Rezoning Transportation Analysis

Petition Number: 2021-132

Date	Description
09-17-2021	First Review (WLB)
10-18-2021	First Review (WLB)

REZONING PLAN
RZ.01

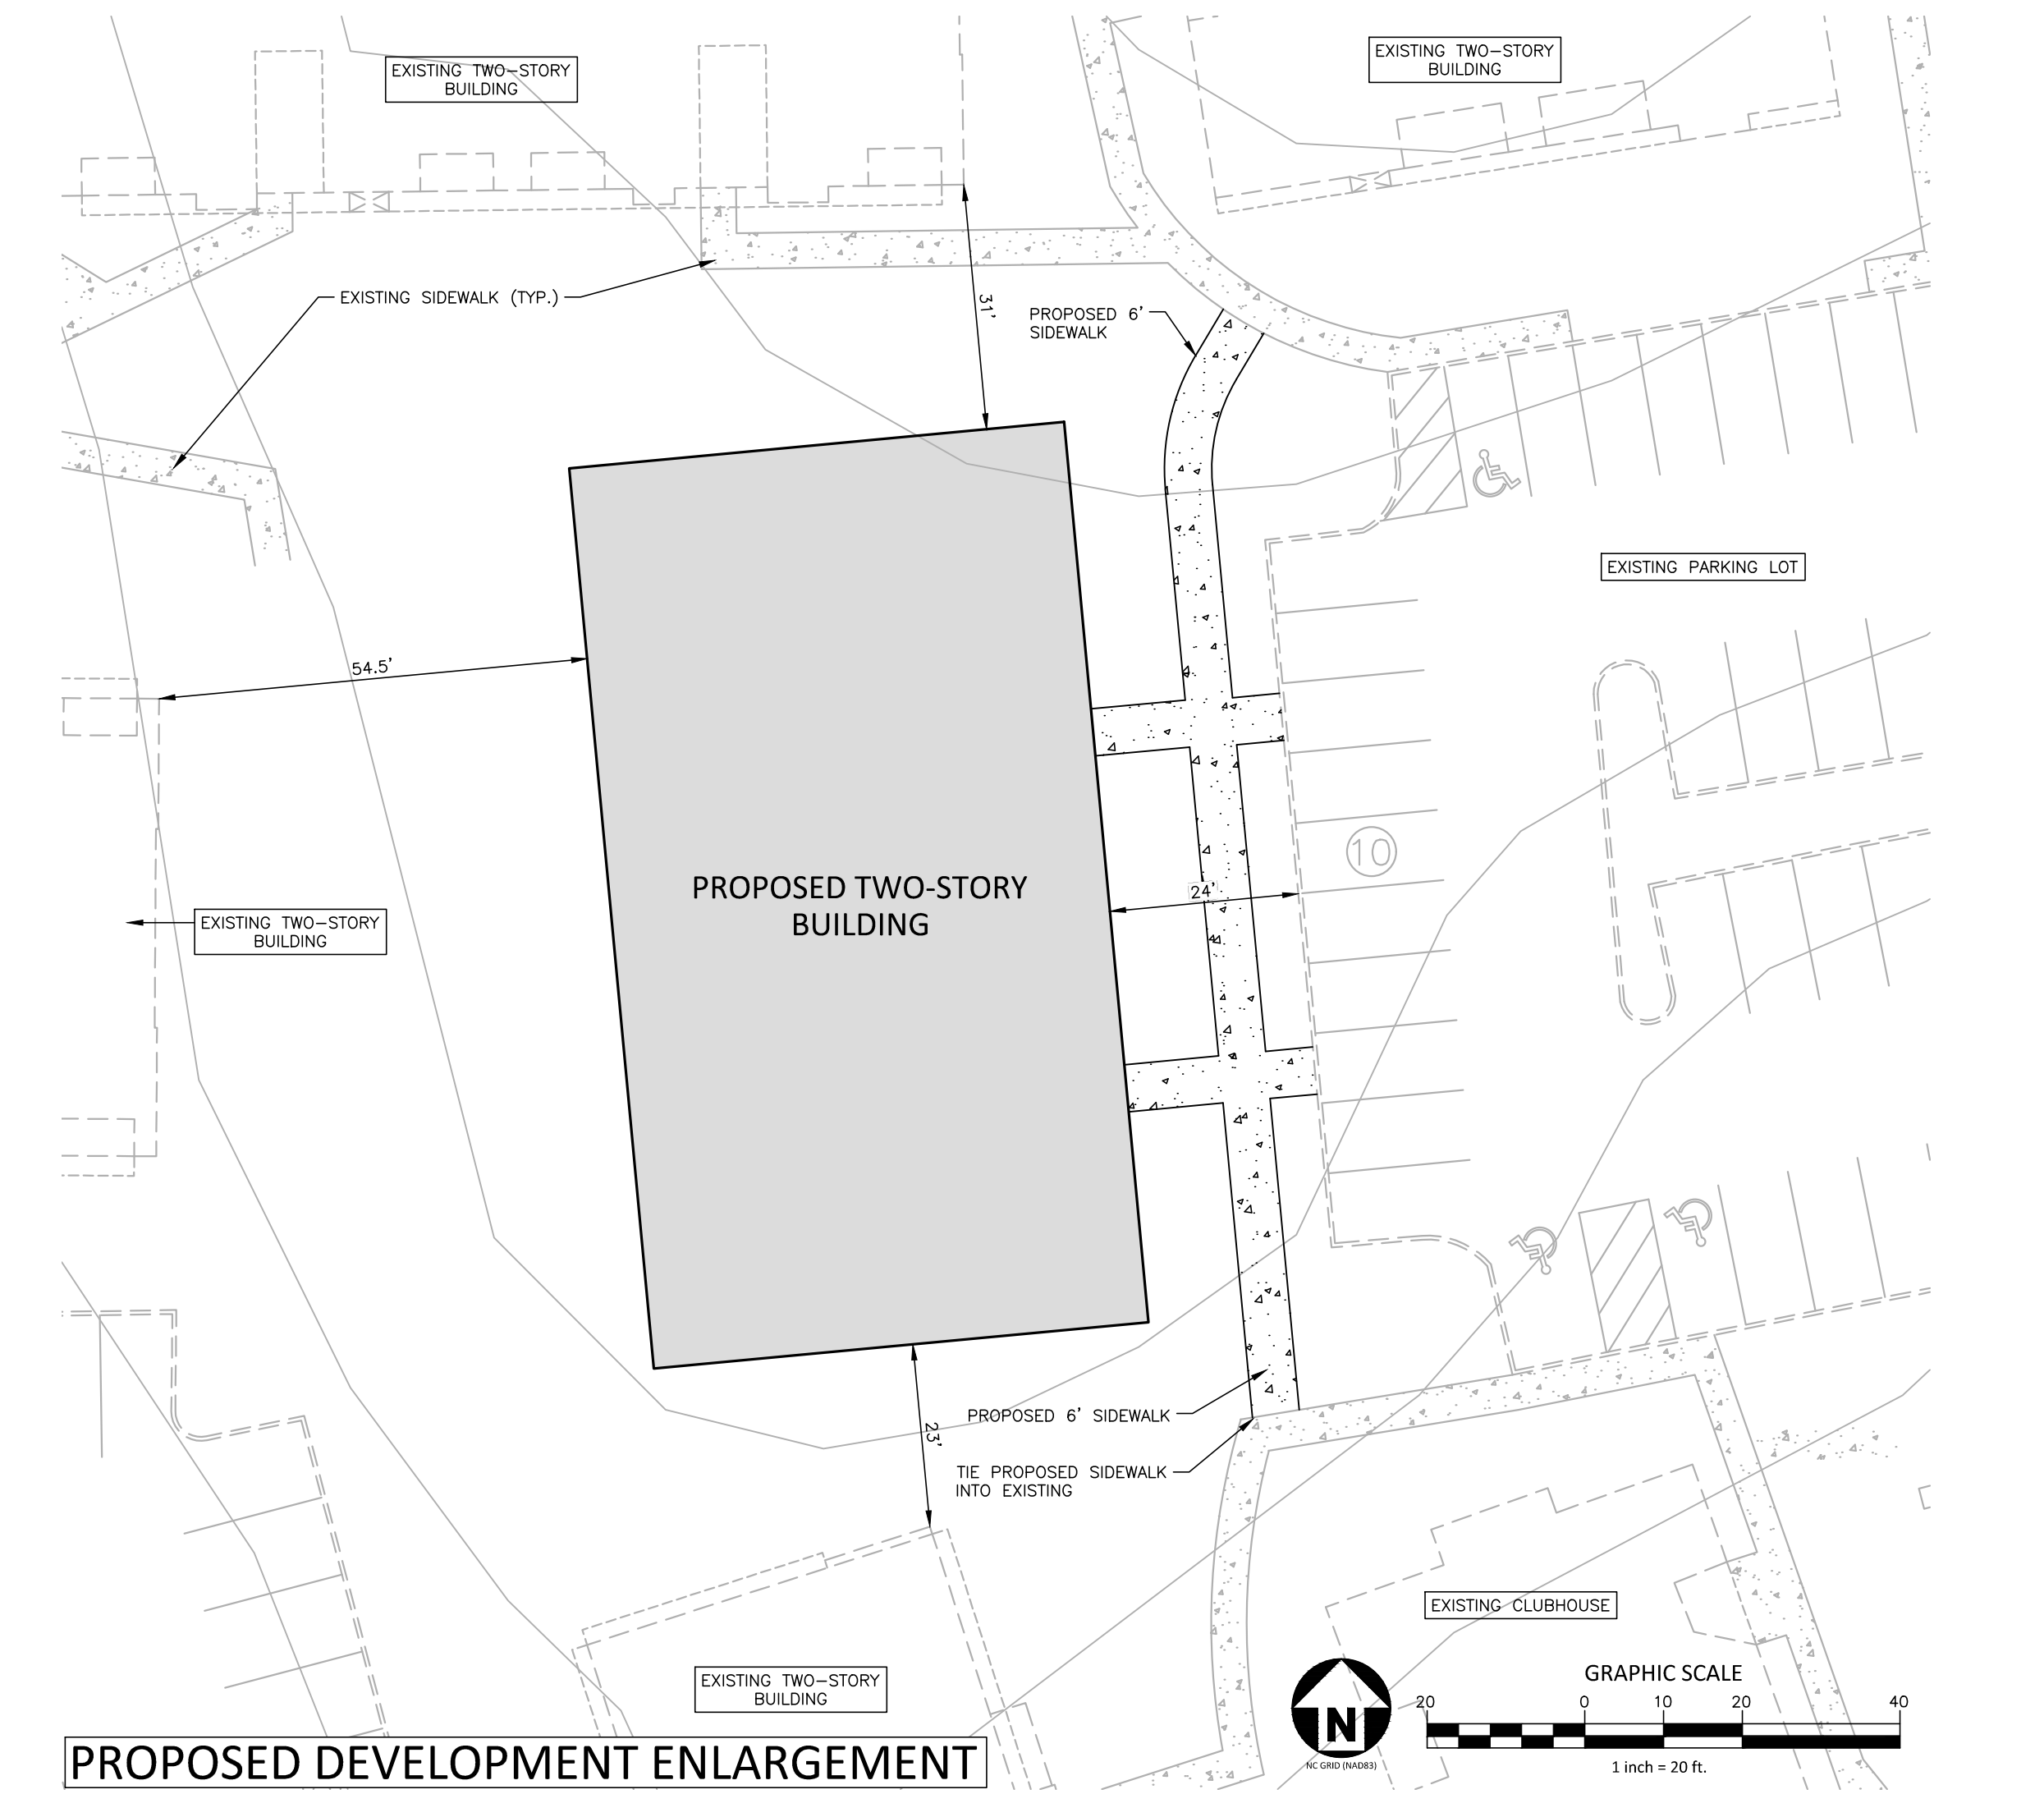
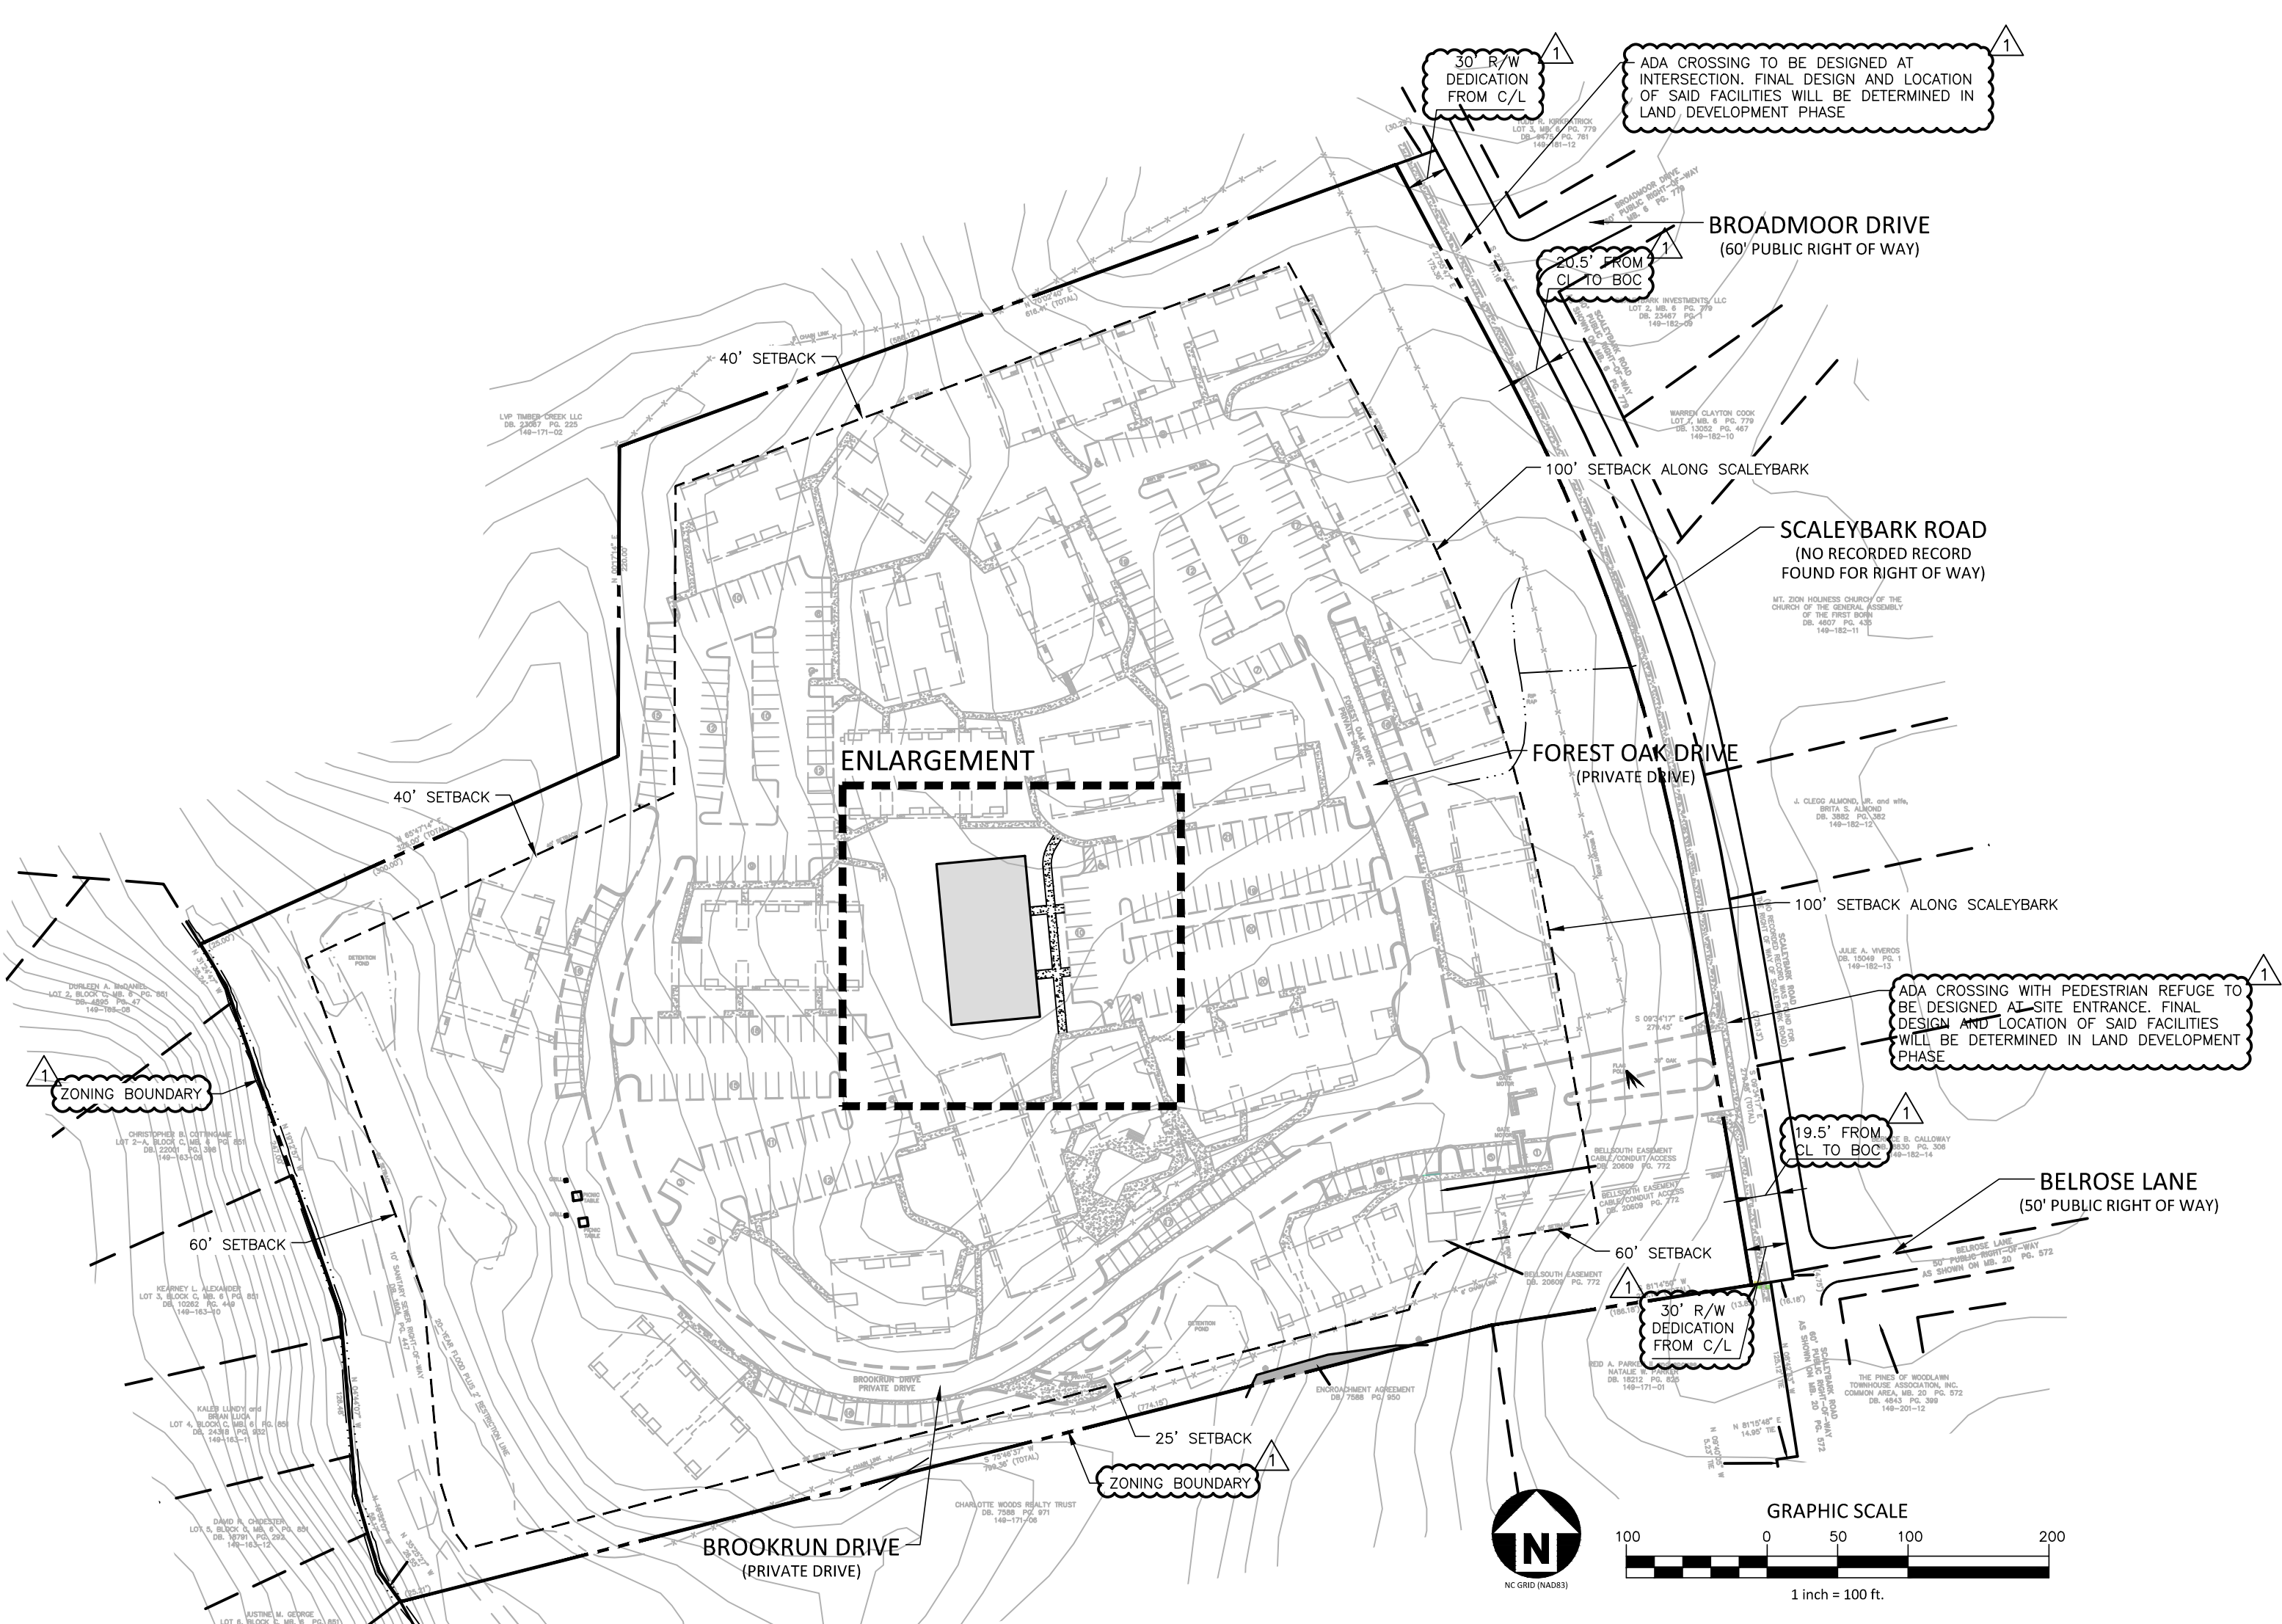
a. ~~Scaleybark Road:~~ The future location of curb and gutter is in its existing location.

~~Label and dimension the curb and gutter from the centerline for each road on the site plan.~~

~~3. Revise site plan and conditional note(s) to commit to dedicate a 30-foot right-of-way from the Scaleybark Road centerline. The site plan shall label and dimension the right-of-way from the road centerline.~~

~~4. Site plan and conditional note(s) revisions are needed to provide ADA-compliant crossing facilities on Scaleybark Road to include curb ramps on all quadrants of existing T-intersections (Broadmoor Drive and at the site's main entrance) and a pedestrian refuge per CLDSM 10.40 at the site's main entrance. The site plan shall label and dimension proposed facilities.~~

- The proposed dwelling units exceeds 12 per acre. Per Chapter 20 Subdivision ordinance, site plan and conditional note(s) revisions are needed to commit to construct an 8-foot sidewalk with 8-foot planting strip along Scaleybark Road. The wider sidewalk meets the Charlotte WALKS Policy. The site plan shall label and dimension both items from the back of curb.

Technical Clarification (10/18/2021) Conditional notes to be updated to state that “The Petitioner will remove and replace the existing substandard sidewalk at the back of curb to meet CDOT standards per Chapter 20 to the City’s Ordinances.”

e. The Petitioner will dedicate via fee simple conveyance along the Site's frontage on Scaleybark Rd. 30-feet of right-of-way as measured from the existing center line of Scaleybark Rd. as generally depicted on the Rezoning Plan. The additional right-of-way will be dedicated prior to the issuance of the first certificate of occupancy. The Petitioner will provide a permanent sidewalk easement for any portion of sidewalk located along the public streets located outside of the right-of-way. The permanent sidewalk easement will be located a minimum of two (2) feet behind the sidewalk where feasible.

f. The Petitioner will install ADA compliant crossing facilities at the existing T intersection of Scaleybark Rd. and Broadmoor Drive and at the intersection of Site's main access on Scaleybark Rd., as generally depicted on the Rezoning Plan. The Petitioner will also modify the existing concrete island in Scaleybark Rd. at the Site's main entrance so that it can function as an additional pedestrian refuge island. Existing crossing facilities that meet ADA standards will not need to be replaced. These proposed improvements will be provided prior to the issuance of the first certificate of occupancy.

g. The Petitioner will replace the existing sidewalk along Scaleybark Rd. with a new sidewalk and planting strip if the existing sidewalk is required to be replaced by Chapter 19. The width of the sidewalk and the width of the planting strip to be determined during the land-development approval process for the Site based on the requirements of Chapter 19.
